DRB Application No.: 08DRB-70228

Project Name: ACADEMY PLACE SUBDIVISION

City of Albuquerque
Planning Department
Inter-Office Memorandum

RE: Project#1004221/ 08EPC-40015 Site Development Plan for Building Permit and 08EPC40018 Amendment to the Zone Map.

SITE DEVELOPMENT PLAN FOR BUILDING PERMIT
Juan Tabo Executive Offices
 5203 Juan Tabo NE
 Albuquerque, New Mexico 87111

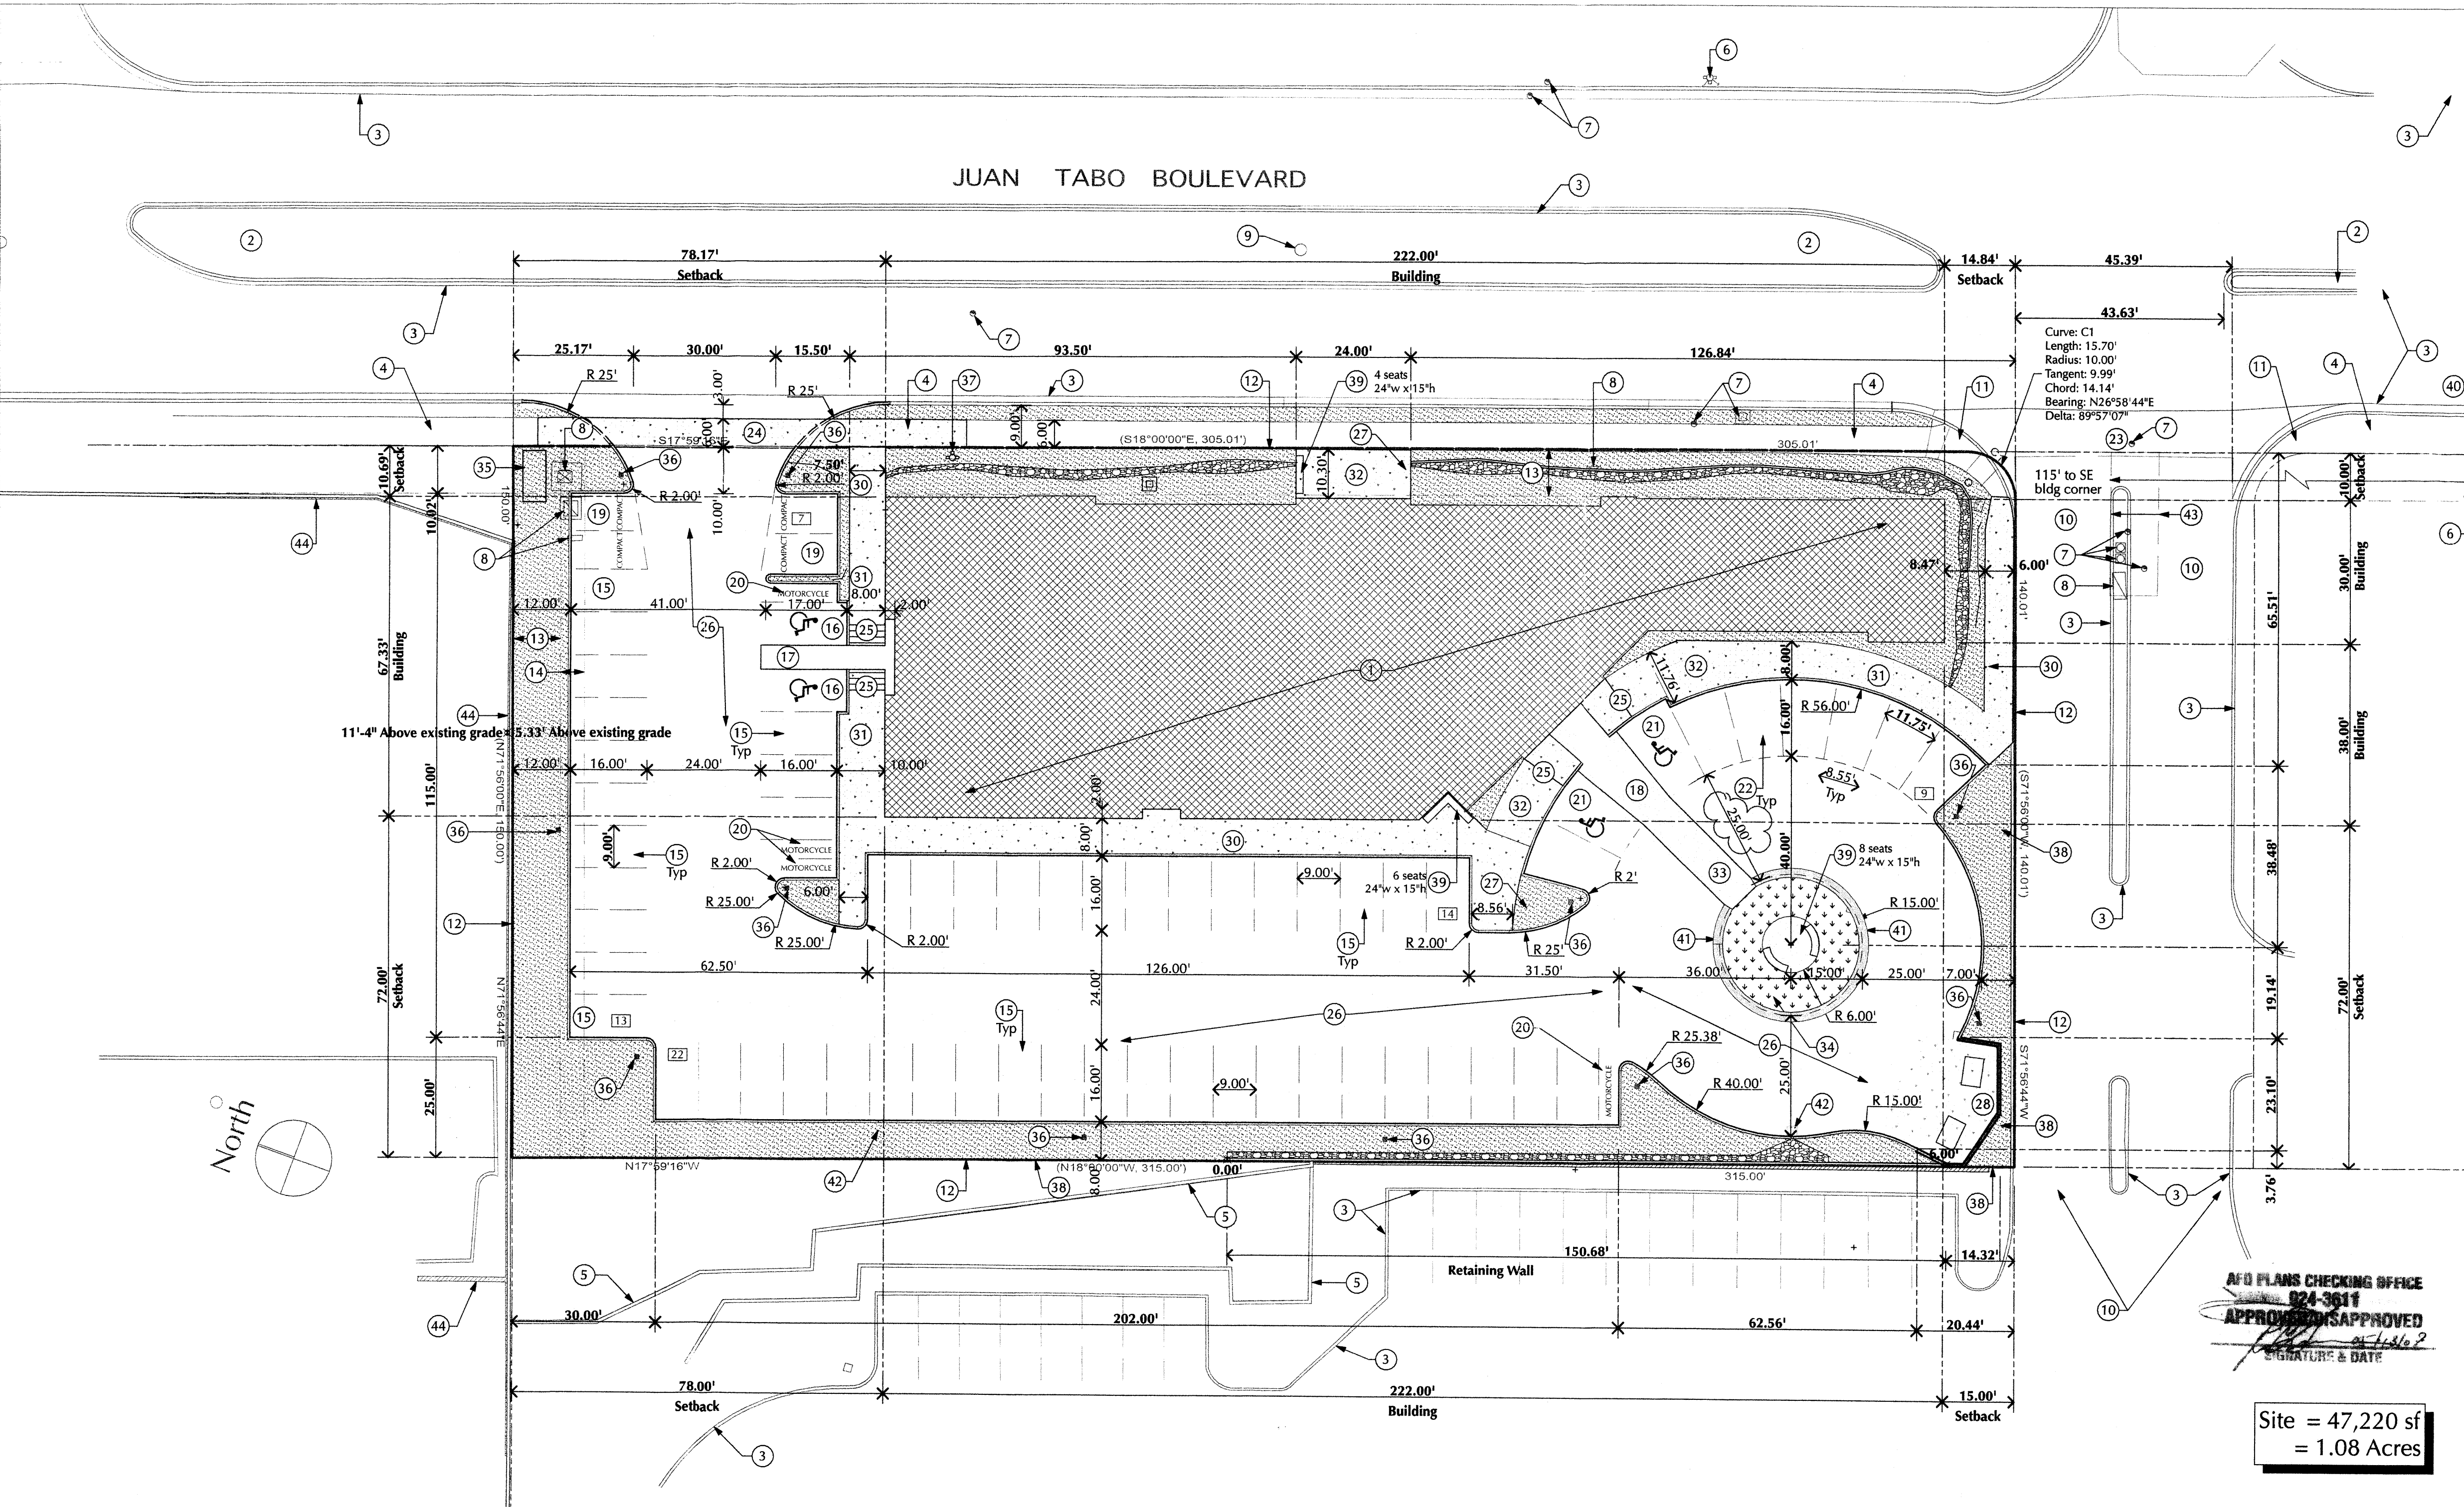
3. Pedestrian/Bicycle Access and Circulation:
 - a. Increase the width of the sidewalk on the south side of the building to 6 feet wide.
The sidewalk width has been increased to 6 feet in width; see Site Plan, Sheet 2.

- b. Increase the width of the sidewalk on the west side of the building in locations where it is only 6 feet wide to between 8 and 10 feet wide (Section 14-16-3-18).
The sidewalk on the west side of the building has been widened to a minimum of 8 feet in width; see Site Plan, Sheet 2.

c. Site drive to be 30' wide with 25' curb returns as a minimum.
The site drive has been amended; see Site Plan, Sheet 2.

S Landscape Plan
Scale: 1" = 20'

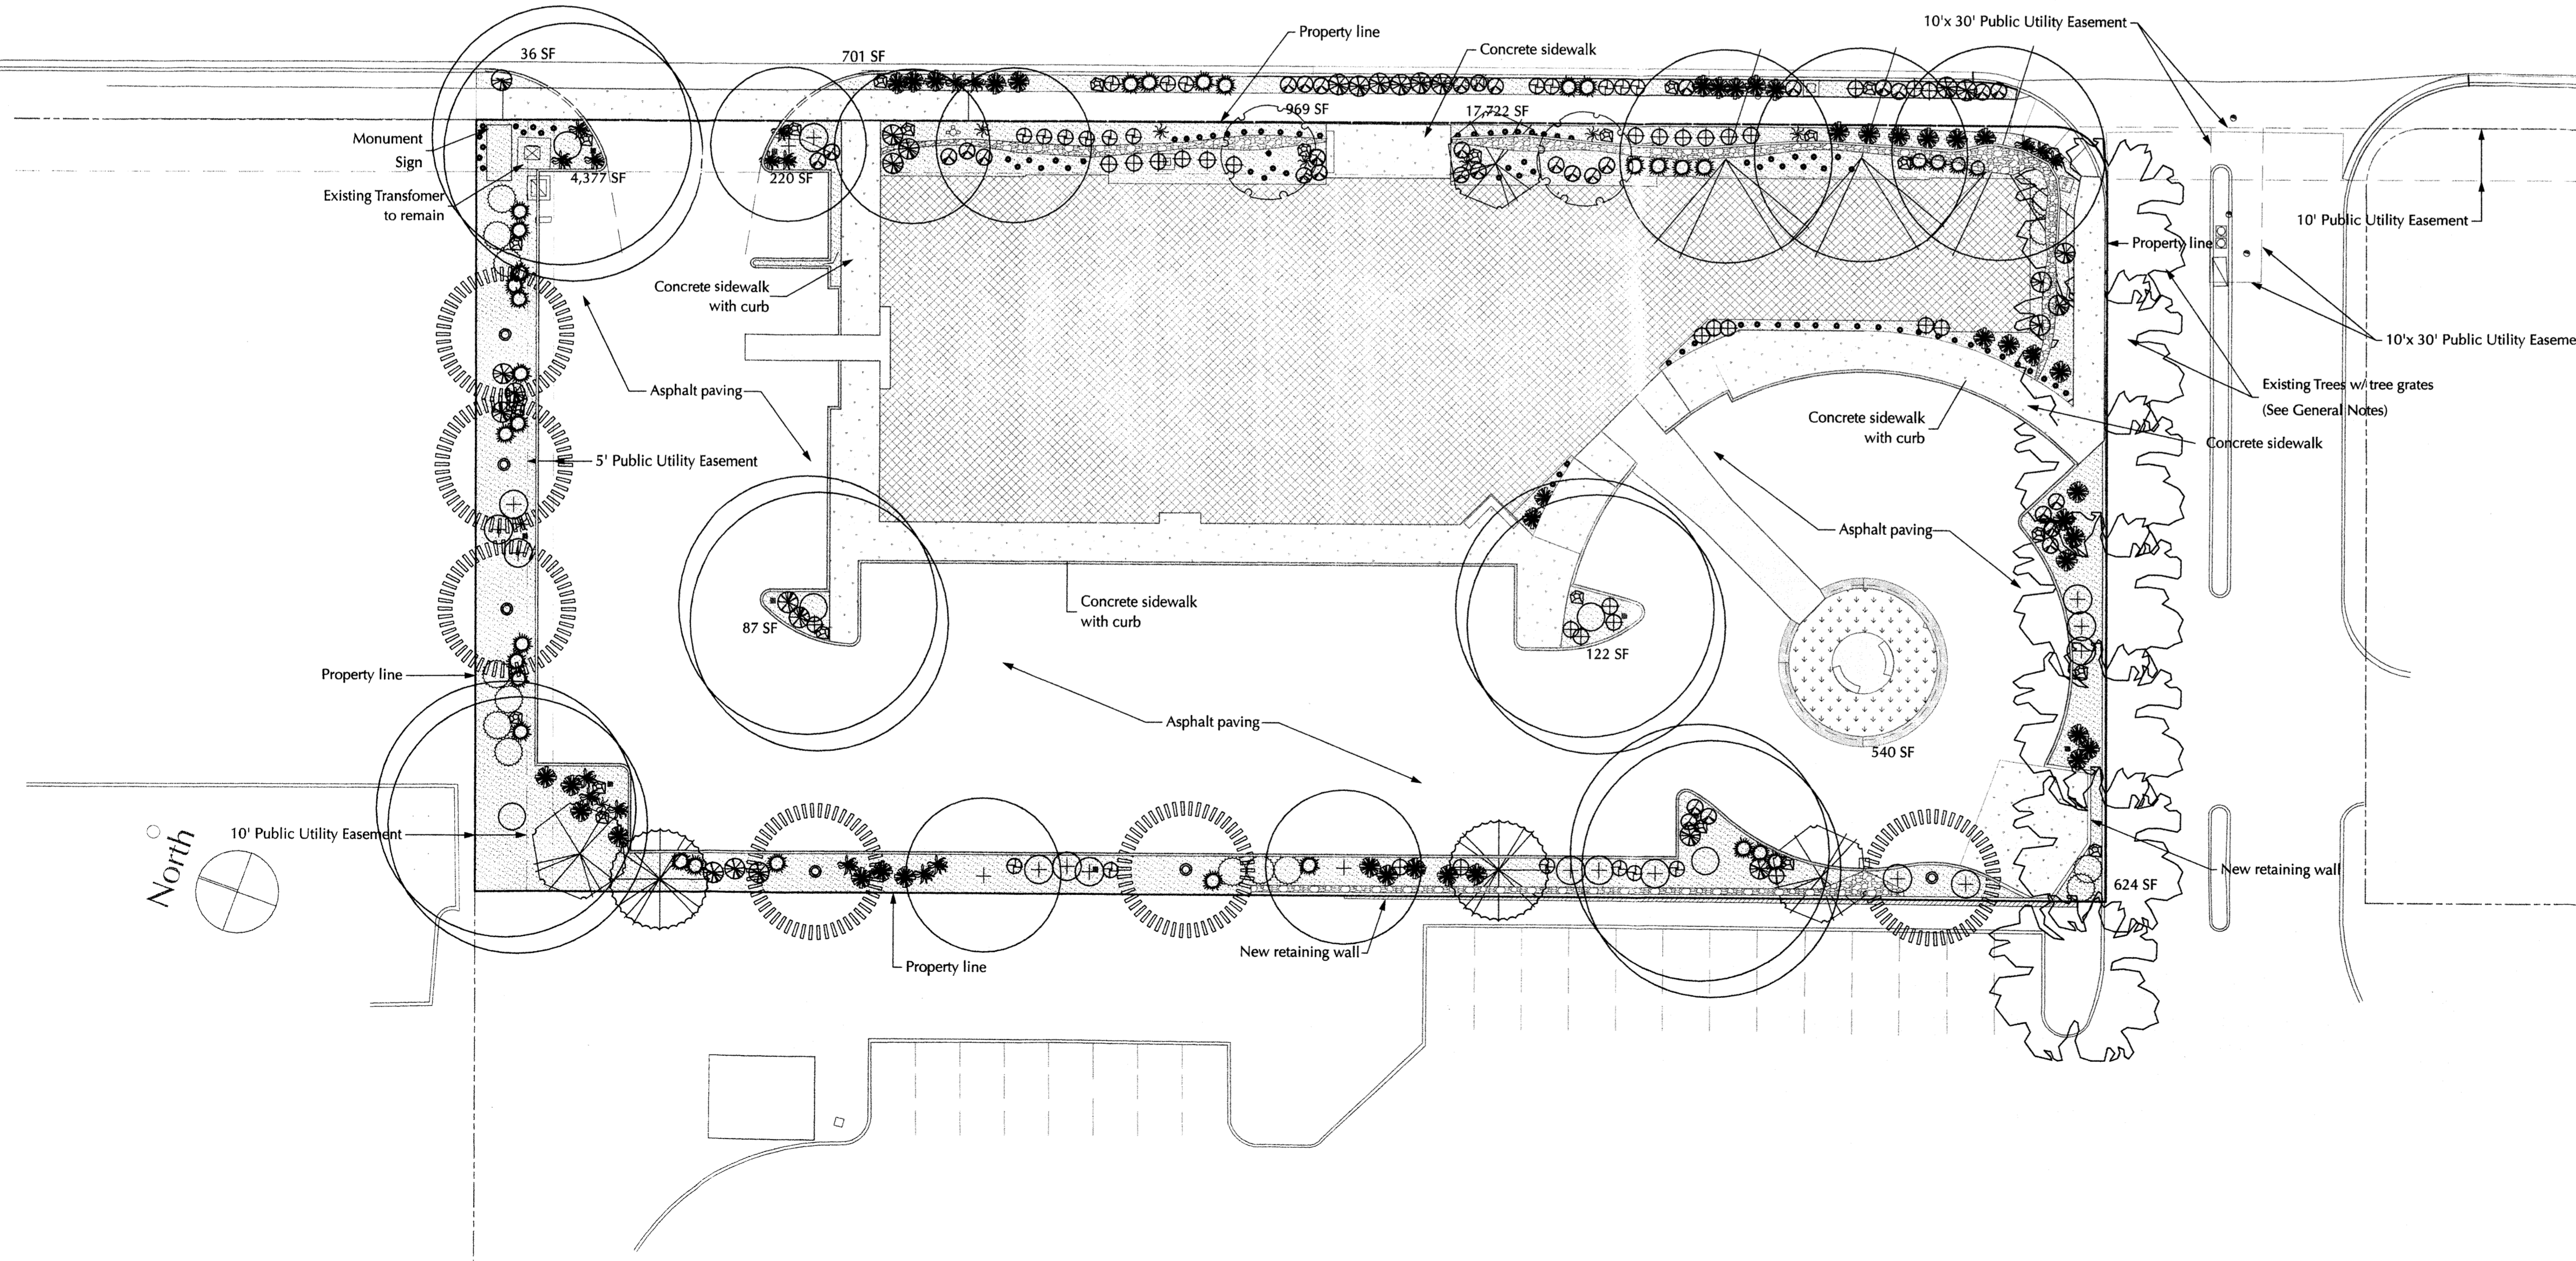
4. Landscaping:
 - a. Replace the grass with a less water intensive water grass such as Blue Gramma or Buffalograss or with xeric plants.
The turf grass has been replaced with Blue Gramma; see Landscape Plan, Sheet 3.

- b. Replace the Modesto Ash (high allergenic potential and medium plus water use) with another tree on the City Forester's list that has lower allergenic potential and water use.
The Modesto Ash has been replaced with Nettleaf Hackberry; see Landscape Plan, Sheet 3.
